**Re: Phase 1 Bedrock at The Trails by La Terra Development at 9300 Woodmont Ave. NW  
Erosion and Sediment Control Plan for Tracts 4 and 5 of the Trails Unit 3A  
Engineer's Stamp Date 4/4/24 (C09E011B)**

Based on the information in your submittal, received on 4/4/24, the above-referenced ESC Plan cannot be approved for a Work Order and Building Permit until the following comments are addressed.

POND D1 CROSS SECTION
SCALE: NOT TO SCALE

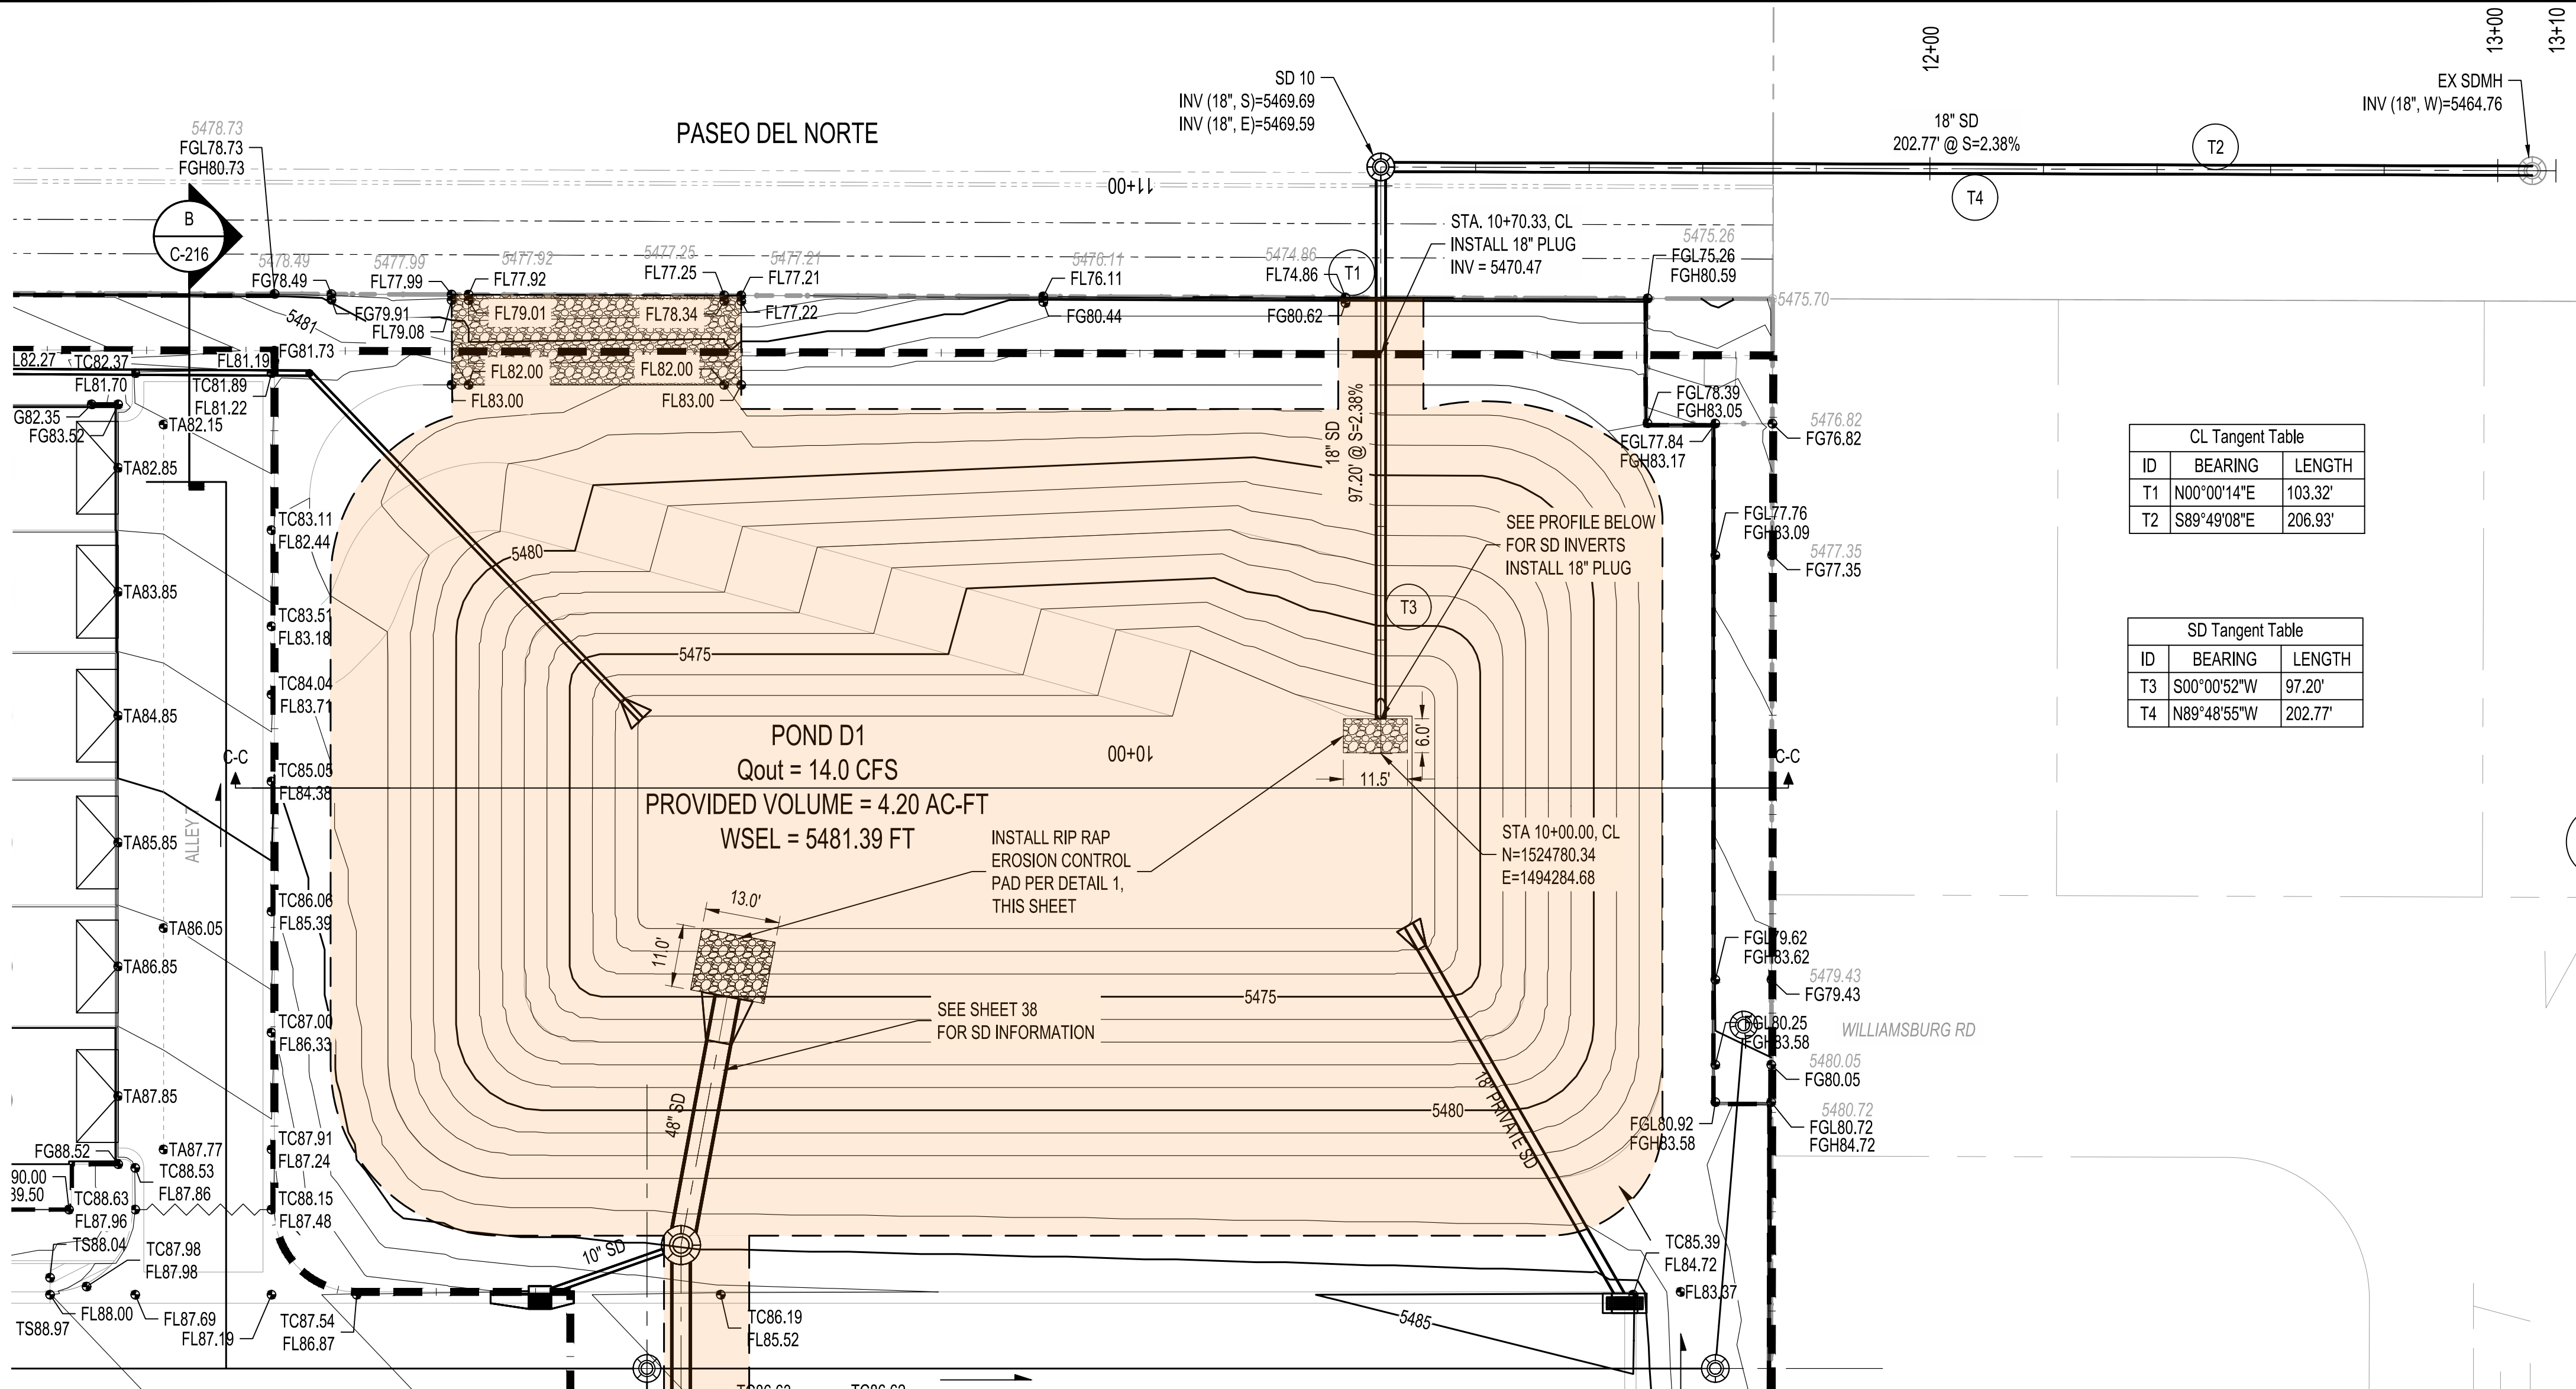
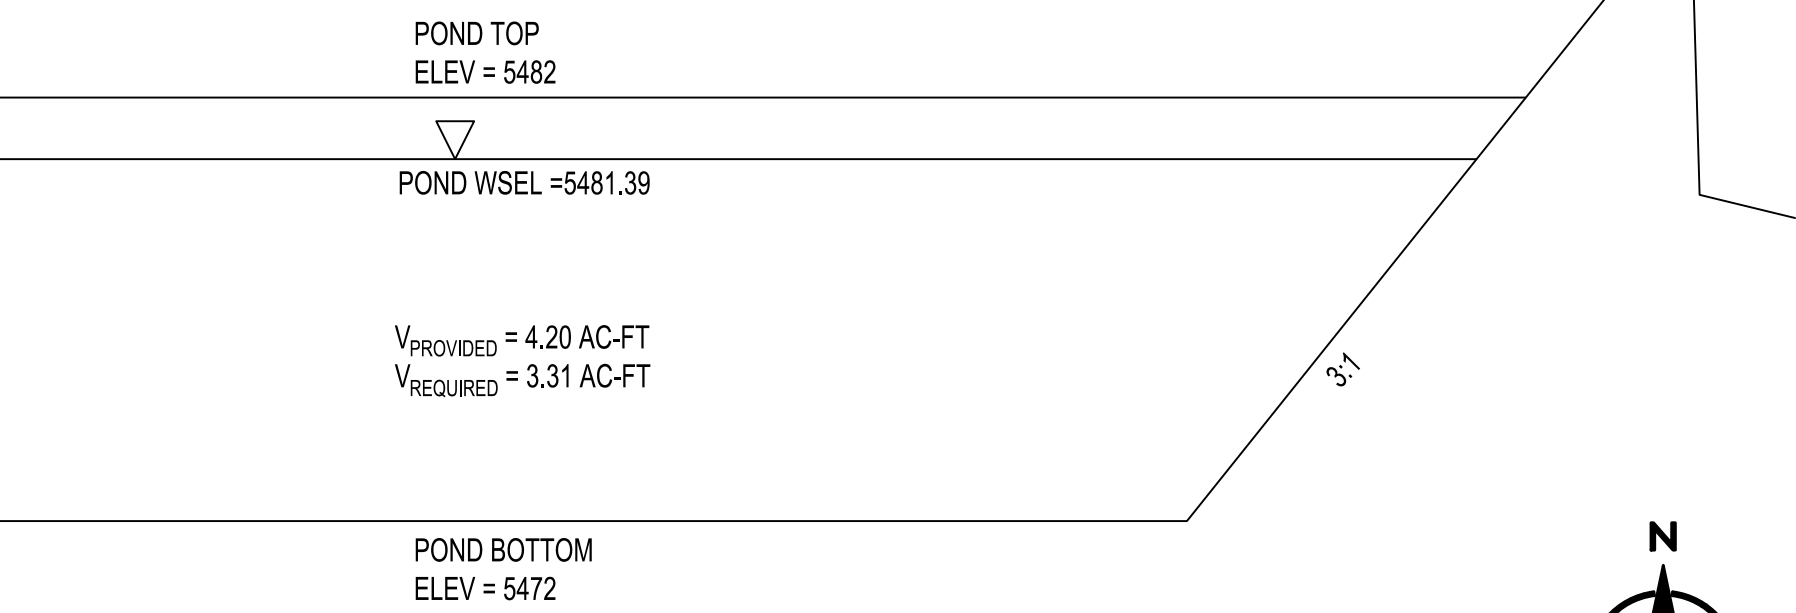
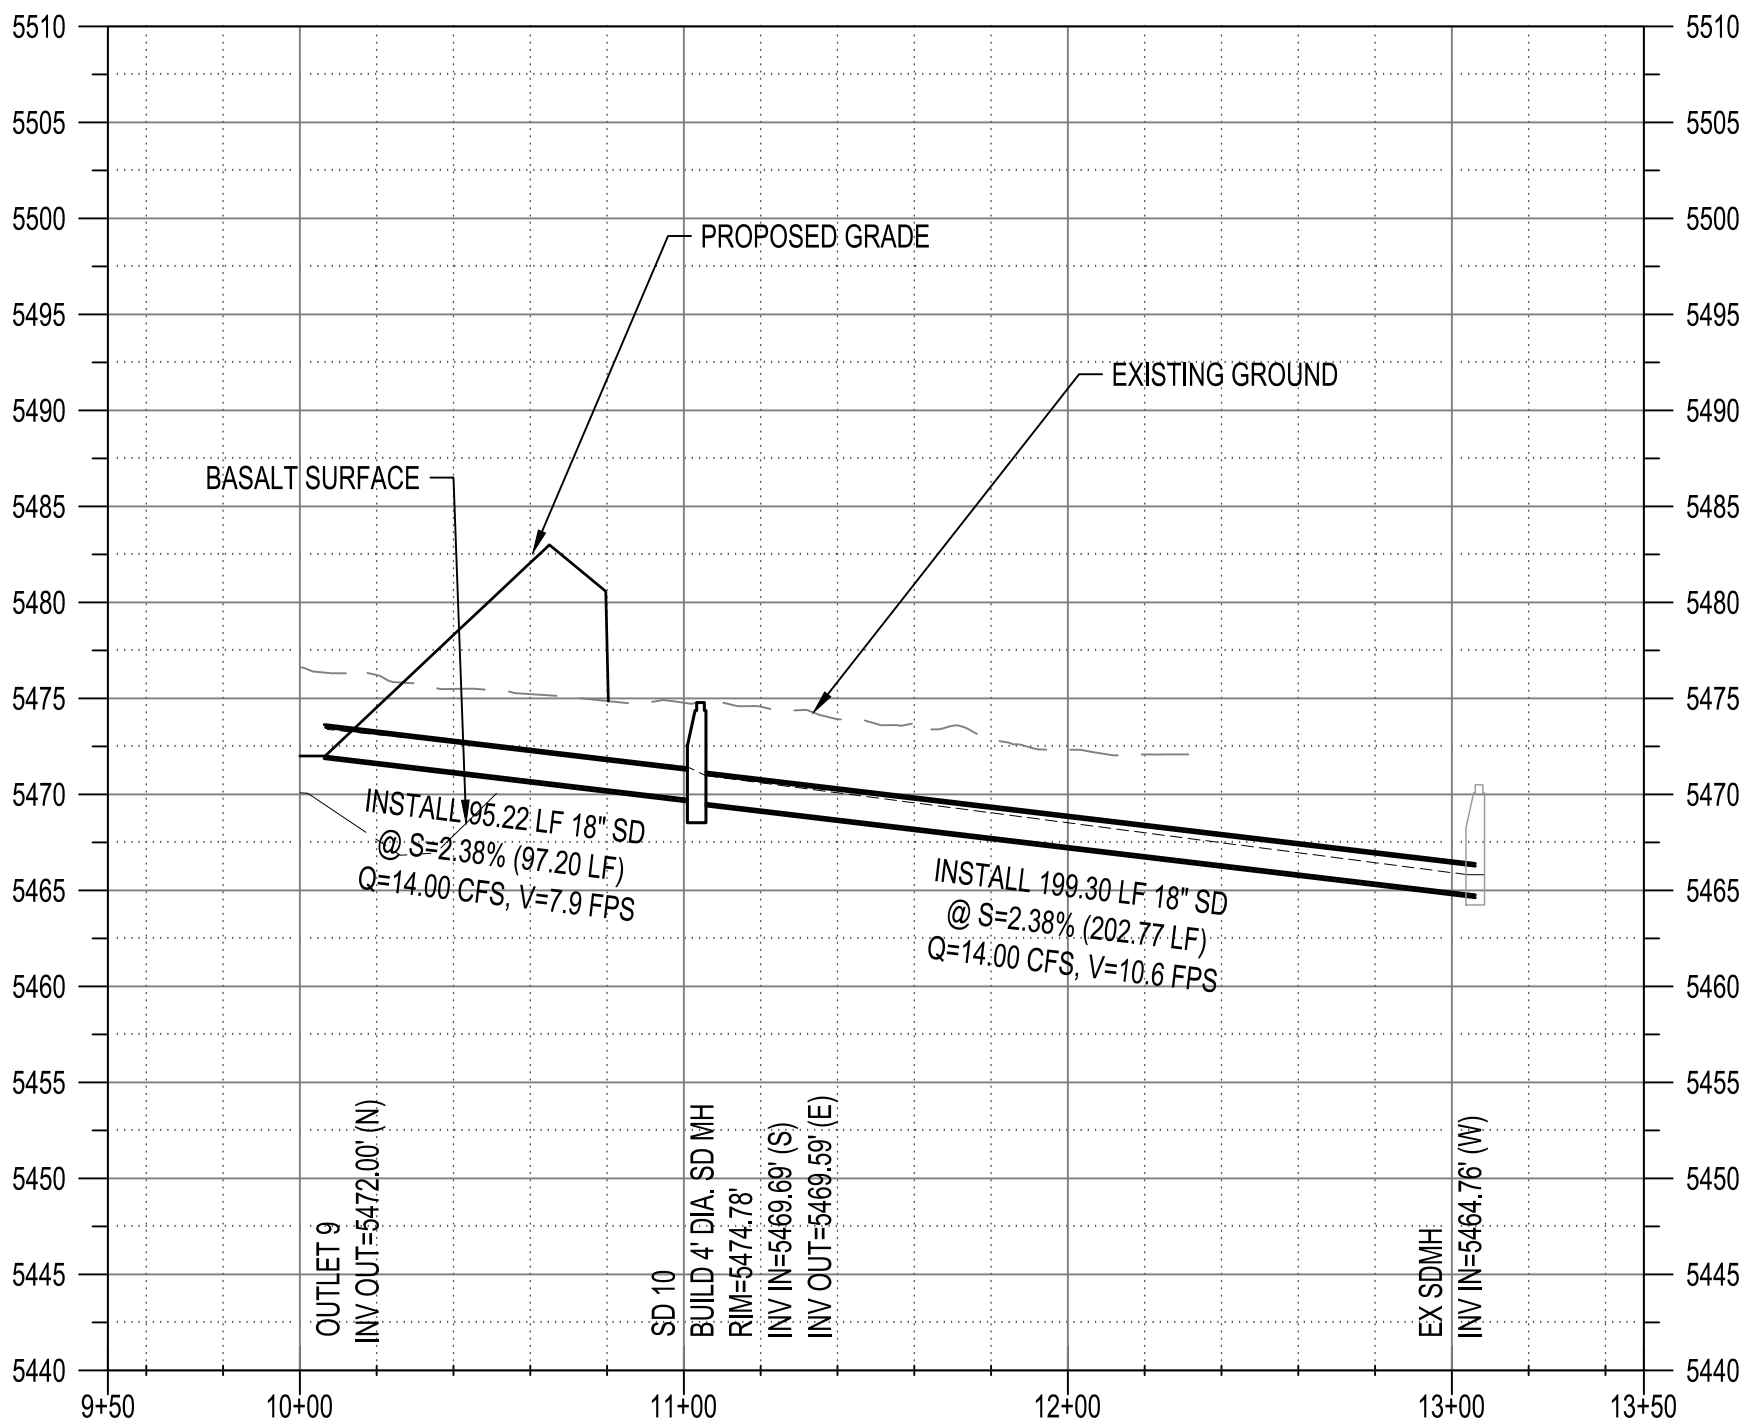
4. Similarly, identify the maximum temporary design volume in Pond D-1 while acting as a temporary sediment basin and provide a narrative description of the function of that pond as a temporary sediment basin until all other construction in phases 1, 2, and 3 is complete. Change
